**Re: Geotechnical Drawing Design Review**  
1400 and 1410 Youville Drive, Ottawa, Ontario  
Pinchin File: 310936.001

Pinchin Ltd. (Pinchin) is pleased to submit this Geotechnical Drawing Design Review Letter to Jim Keay Ford Lincoln Sales Ltd. (Client) for the proposed commercial development to be located at 1400 and 1410 Youville Drive, Ottawa, Ontario (Site).

Drawing Title: **GRADING, DRAINAGE AND EROSION & SEDIMENT CONTROL PLAN**

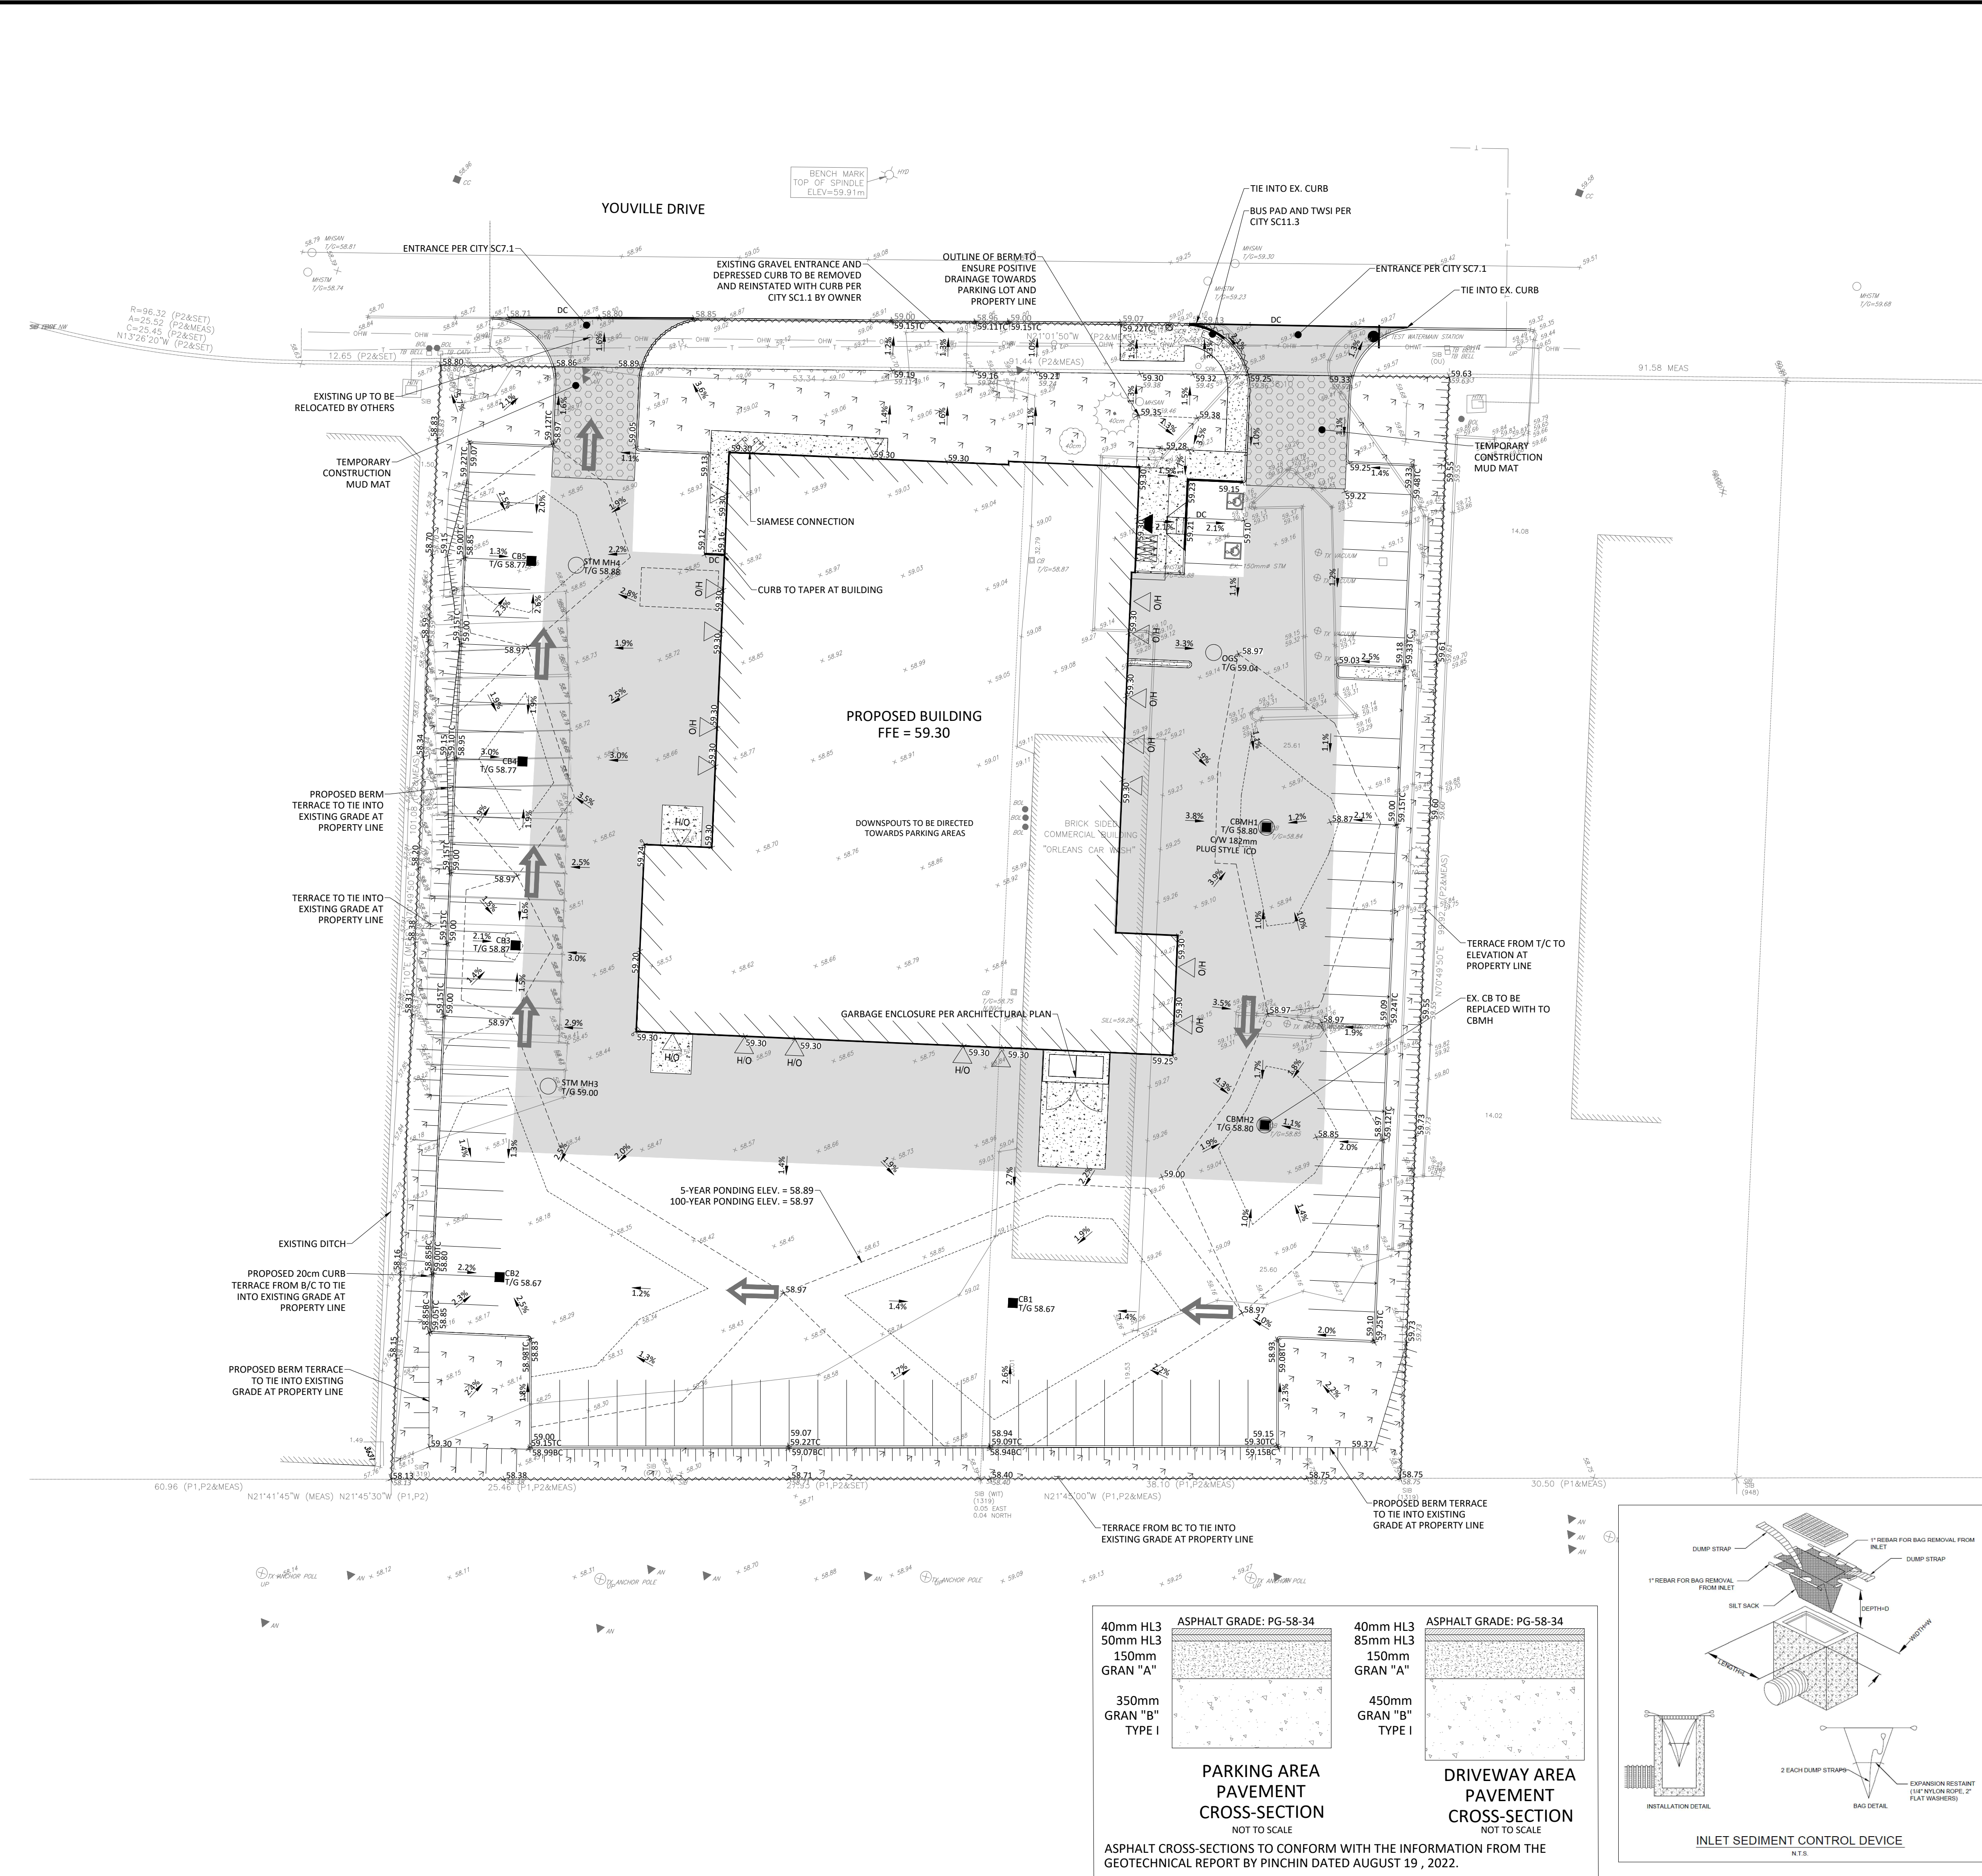
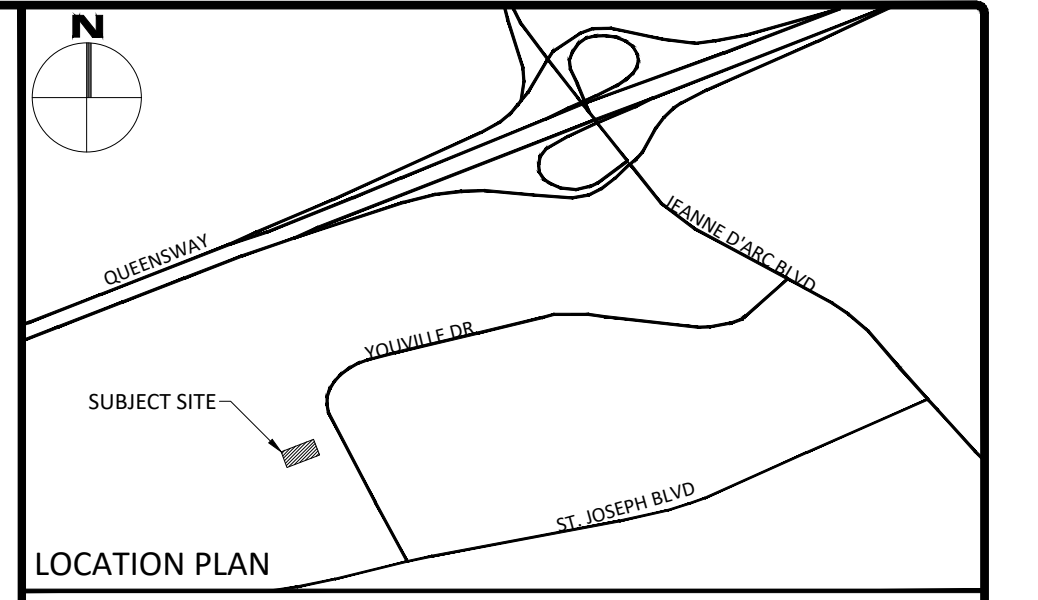
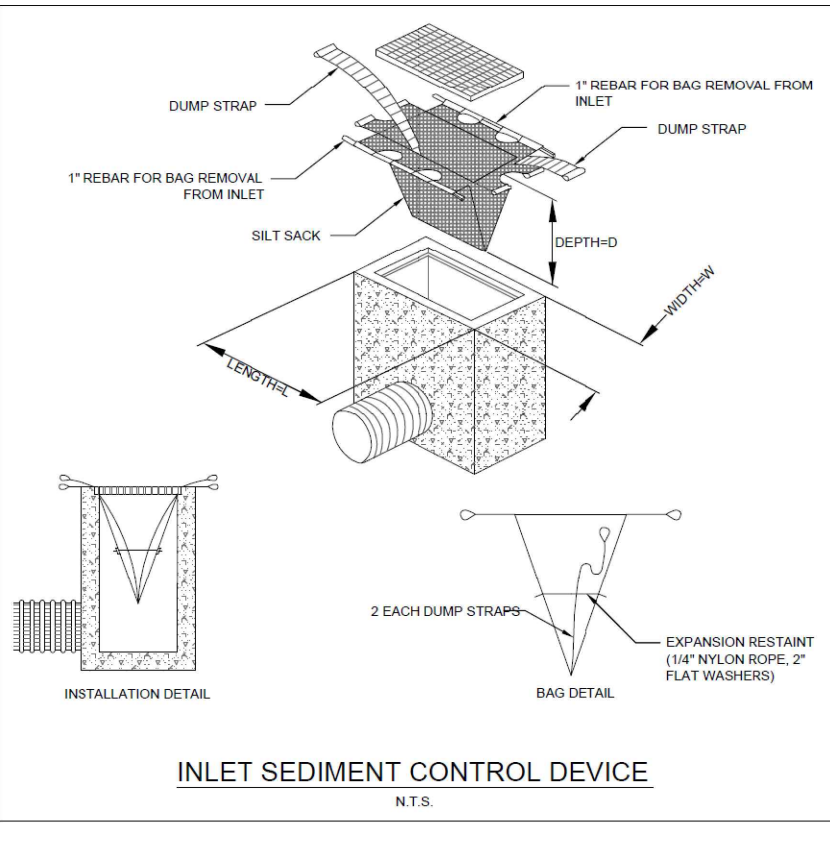
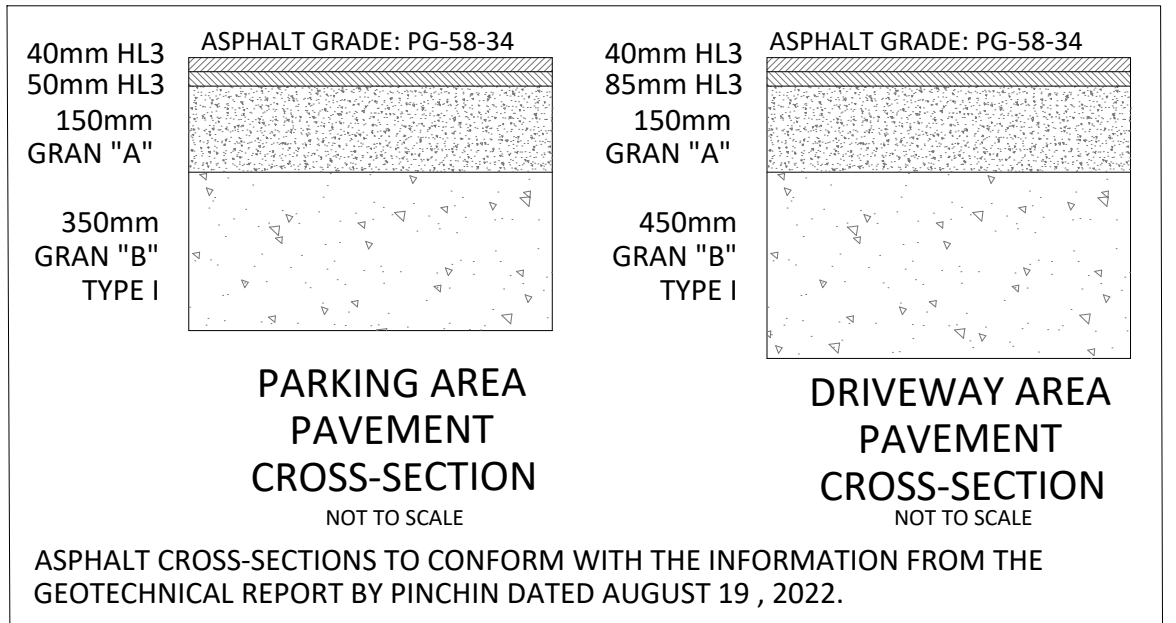
- Drawing entitled *“Grading, Drainage, and Erosion & Sediment Control Plan”*, prepared by McIntosh Perry, project number CCO-23-0480, drawing number C101, dated February 2, 2023;

Based on Pinchin's review of the proposed footing sizes and associated soil bearing resistances required, the proposed footing sizes for the development are considered to be acceptable for the subsurface soil conditions encountered in the Pinchin 2022 Report. In addition, Pinchin has reviewed the proposed grade raises for the development and considers them to be acceptable.
